Objective: Secure the Windspire to the foundation with standard height locknuts.

1.2kW WINDSPIRE – BASE CONNECTION

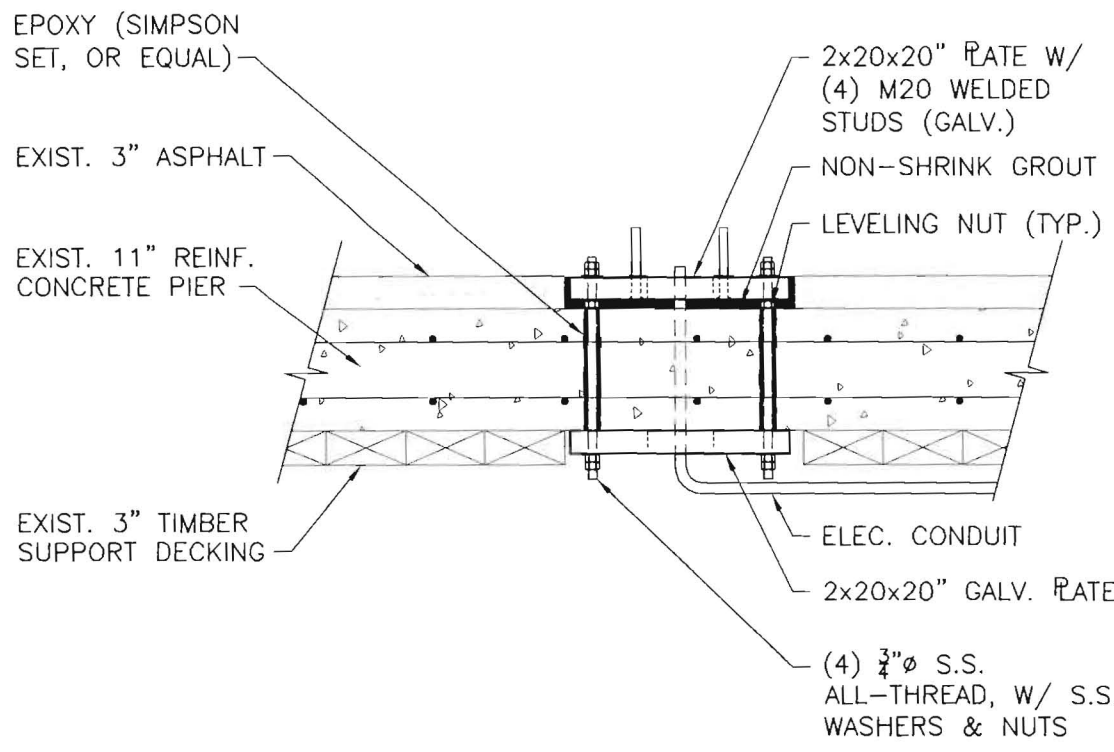
1. The Windspire utilizes updated parts to implement standard height locknuts to secure it to the foundation. This addendum should complement a unit installation with foundation studs that protrude 4.5" from the concrete surface.
2. Secure the bottom hinge plate to the foundation with four of the eight supplied standard $\frac{3}{4}$ -10 nylock nuts.
3. Add to the top of the four nylock nuts one metal washer, four rubber washers, then one more metal washer, as seen in the figure below.
4. Continue with normal installation, and after raising the Windspire, use one metal washer, one rubber washer, one metal washer, and then the remaining four standard height locknuts to secure the Windspire to the foundation studs.
